CITY OF ALBUQUERQUE

Re: New Day Expansion – 2820 Ridgecrest S.E.
Request for Temporary C.O. – **Accepted = 30-Days**
Engineer's Stamp dated: 02-07-2013
Certification dated: 10-1-13

M18/D014

DRAWN BY BJB
REVIEWED BY FCA
DATE
PROJECT NO. 11-0116
DRAWING NAME
SHEET NO. CG-101

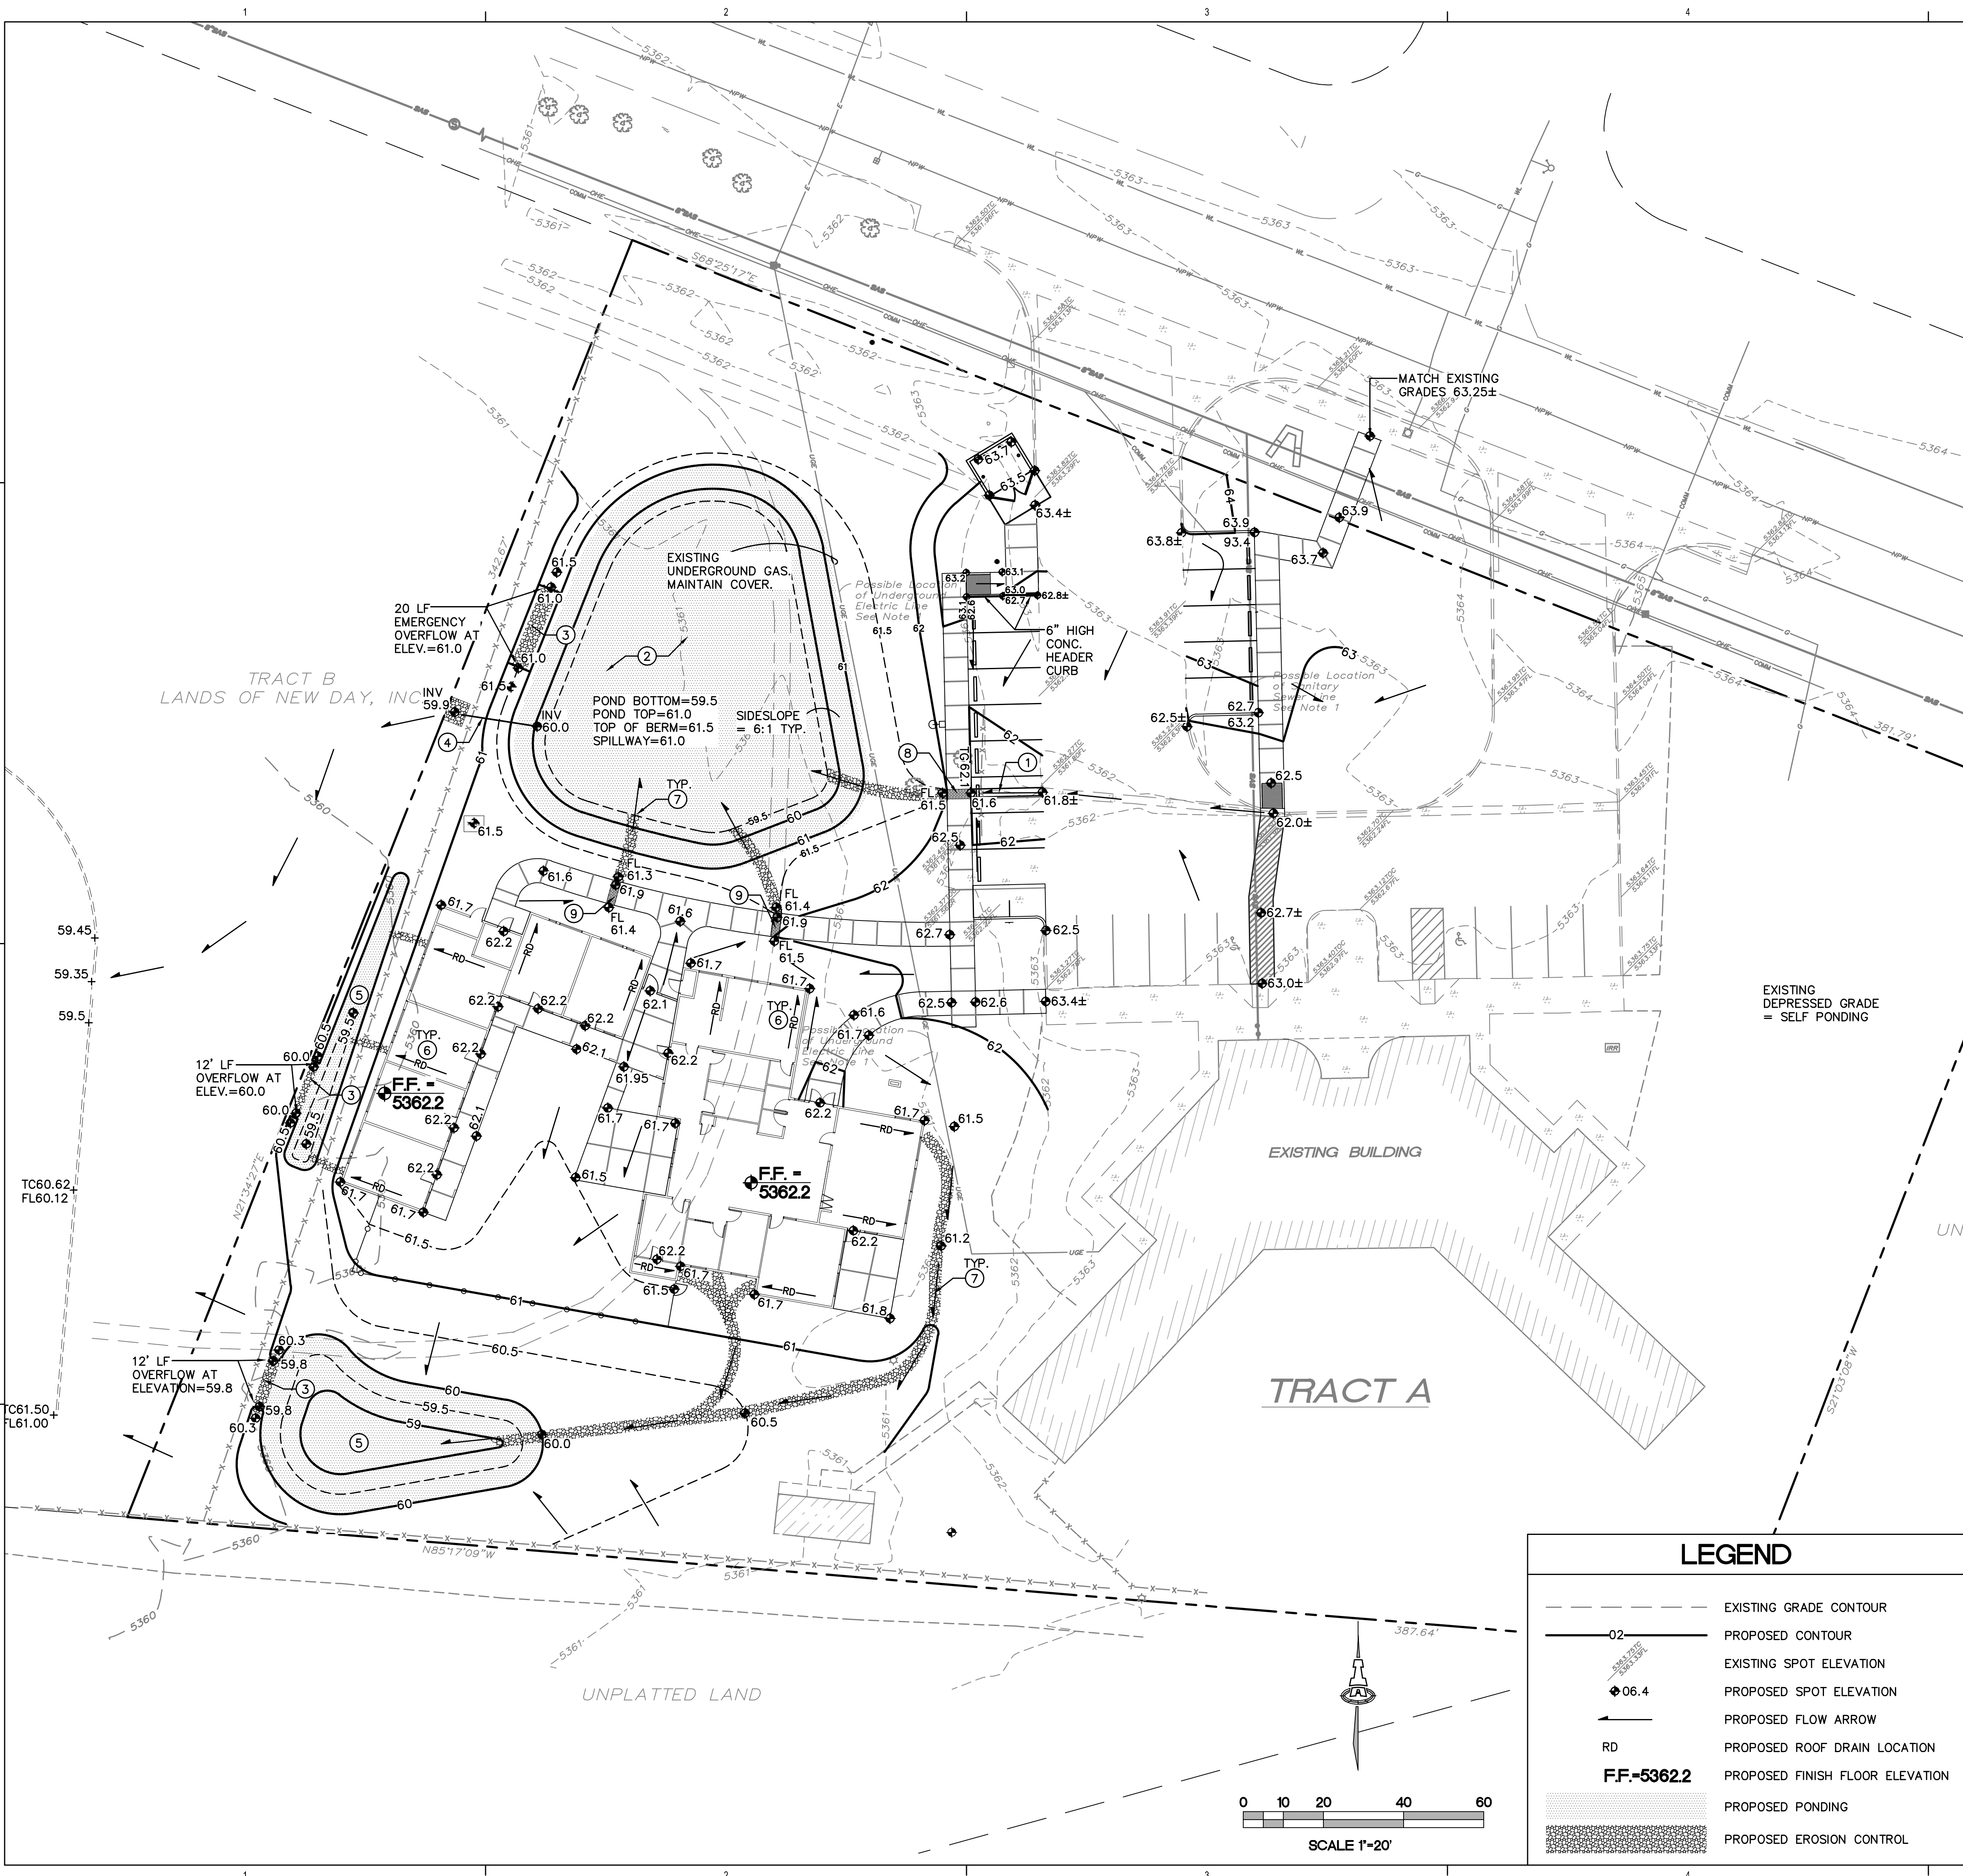
Based upon the information provided in your Certification received 10-01-2013, the above referenced Certification is NOT acceptable for a release of a Permanent Certificate of Occupancy by Hydrology. The information provided suggests deficiencies in the main, detention pond, and fails to document the required vs. As-Built detention pond volumes.
